Our ref: NO/2025/117121/02-L01
Your ref: 3/2025/0870
Date: 26 November 2025

**PROPOSED DEMOLITION OF FORMER MOTOR SERVICES BUILDING AND
CONSTRUCTION OF NEW OFFICE BUILDING.**

**18 ACCRINGTON ROAD (FORMER WHALLEY MOTOR SERVICES), WHALLEY,
BB7 9TD**

Environment Agency position

Drawing Title  
**Proposed Site Plan**

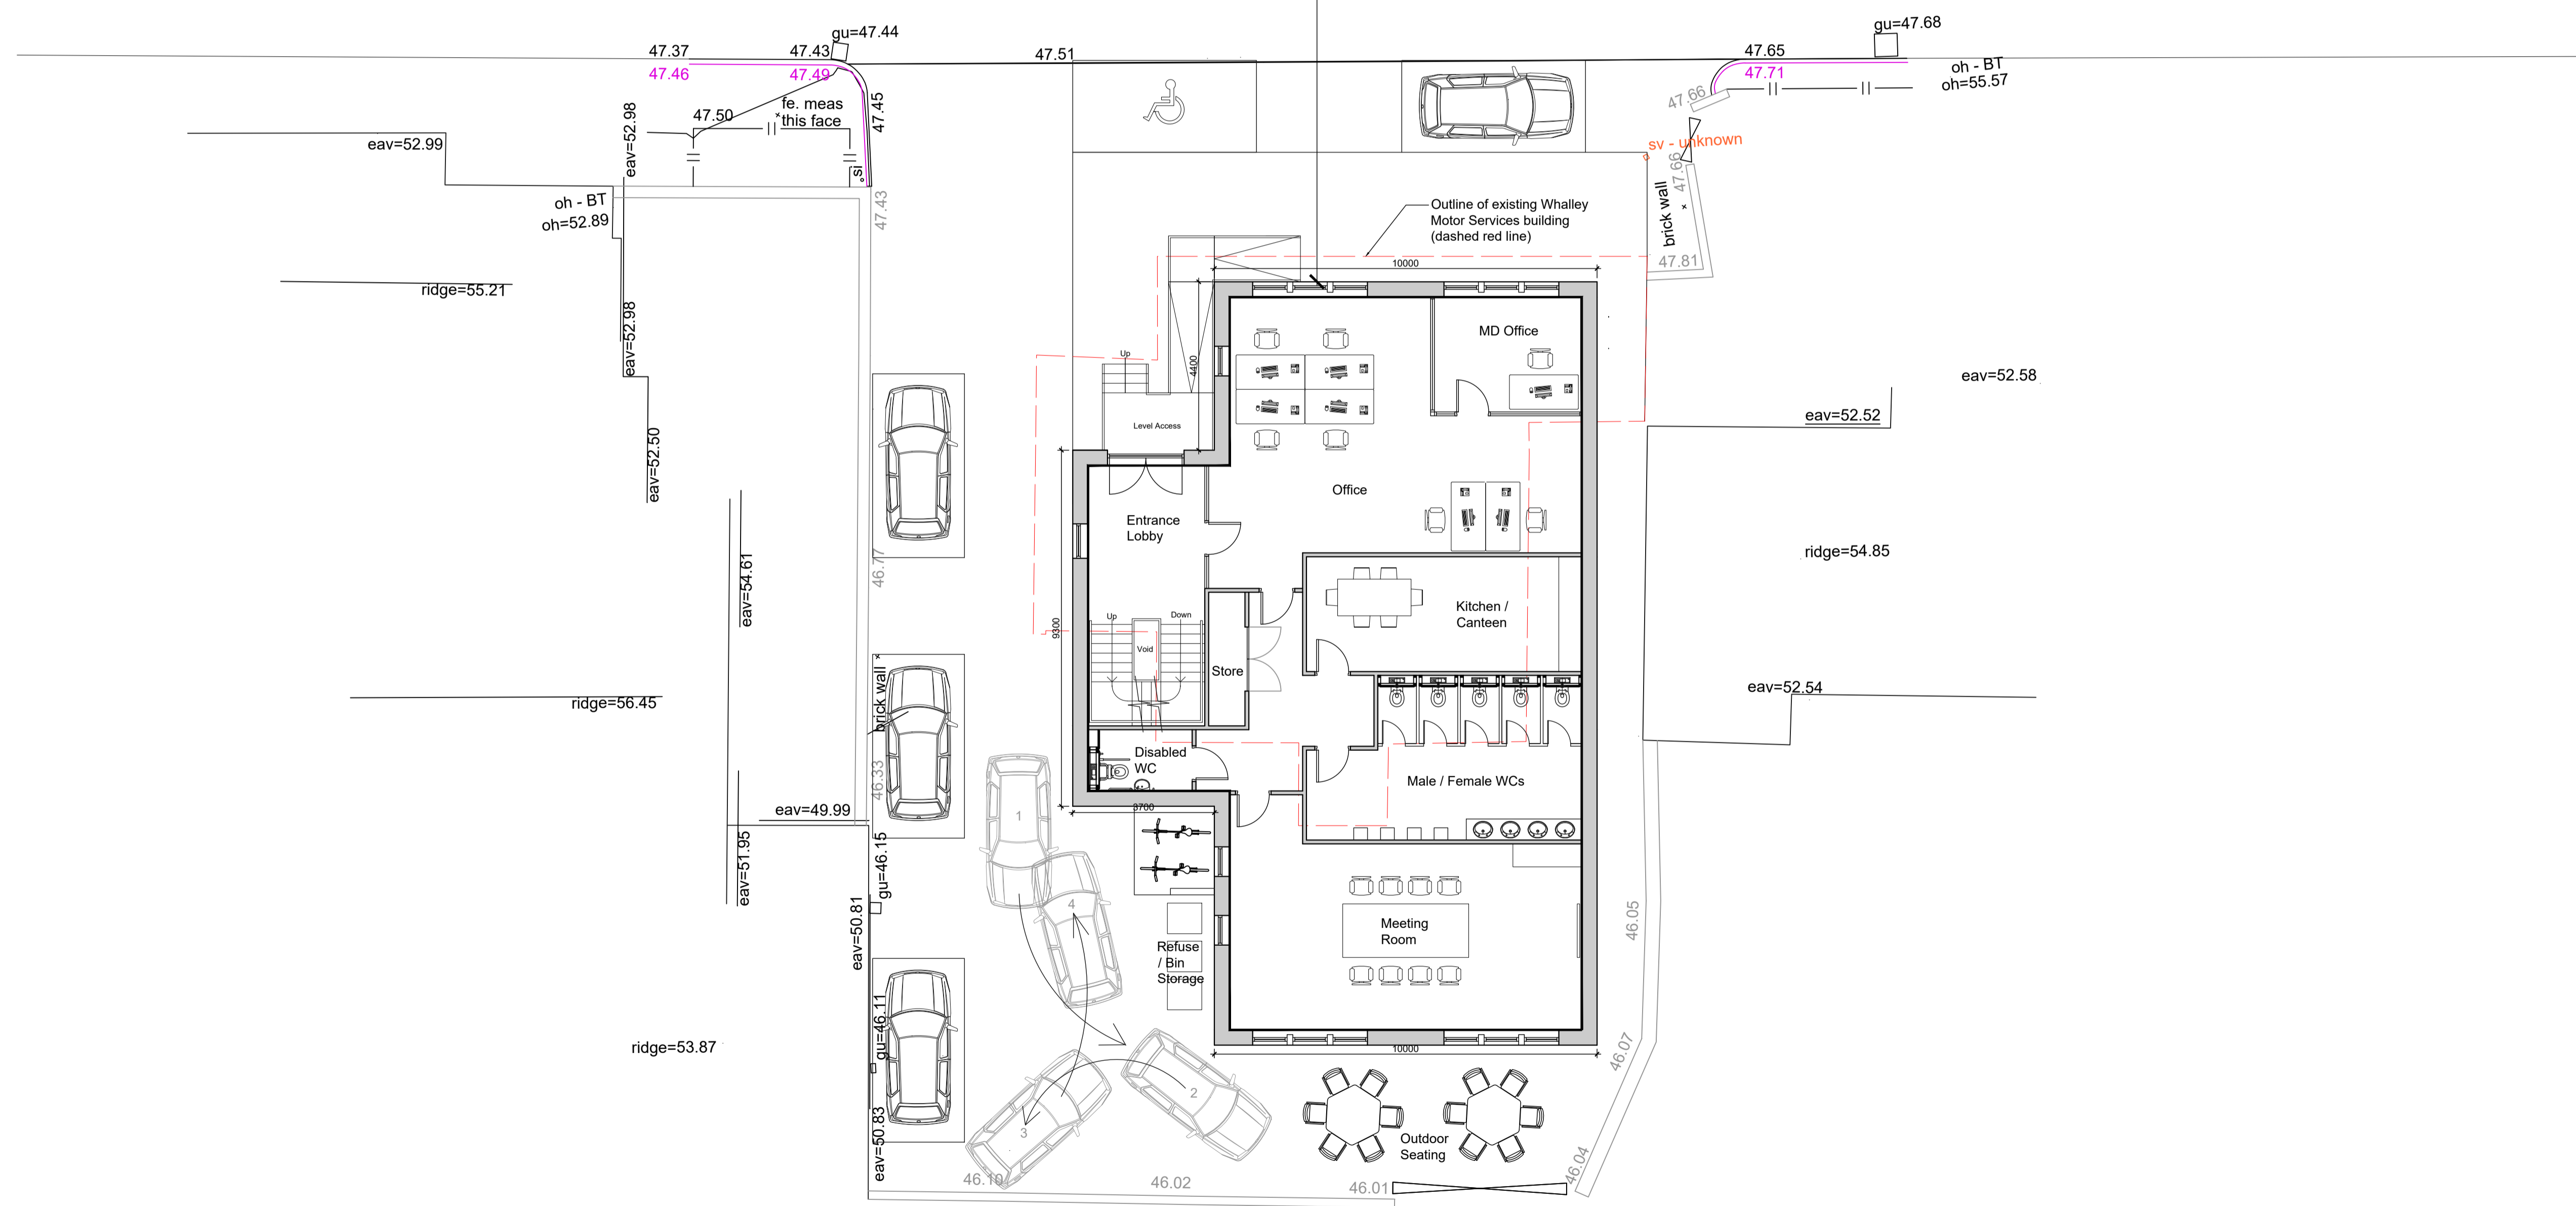
The southern extent of the new building lies within Flood Zone 3 which is land defined
by the Planning Practice Guidance as having a high probability of flooding. In our

We have not received a revised FRA document, however the letter submitted in response to our previous objection states that '*the extension (within the flood zone area) beyond the existing building footprint is calculated at 100sqm*'. In addition, the applicant has calculated that the proposed building footprint would result in 30 cubic metres of floodwater being displaced. While the applicant has calculated the displacement volume, it fails to provide any solutions or mitigation measures to prevent the displacement of floodwaters elsewhere. The individual effect of not carrying out compensation works for the loss of floodplain storage may appear to be minor, but we are concerned by the cumulative effect of such proposals.

The NPPF states that '*there is no lower volume limit below which compensation is not required*'. In this instance we do not deem it acceptable to remove our objection based on 'inconsequential' volumes, we instead must be mindful of cumulative impacts especially given the history of flooding in Whalley itself. This is a sufficient reason for maintaining our objection to planning permission.

The site could be reconfigured to avoid the development extending further into Flood Zone 3 and therefore potentially displacing floodwaters elsewhere or the applicant should further assess the need for flood storage compensation.

To overcome our objection, the applicant should submit a revised FRA which addresses the points highlighted above. The revised FRA should provide consideration in relation to the impact of fluvial flood risk elsewhere. Where possible, it should reduce flood risk overall.
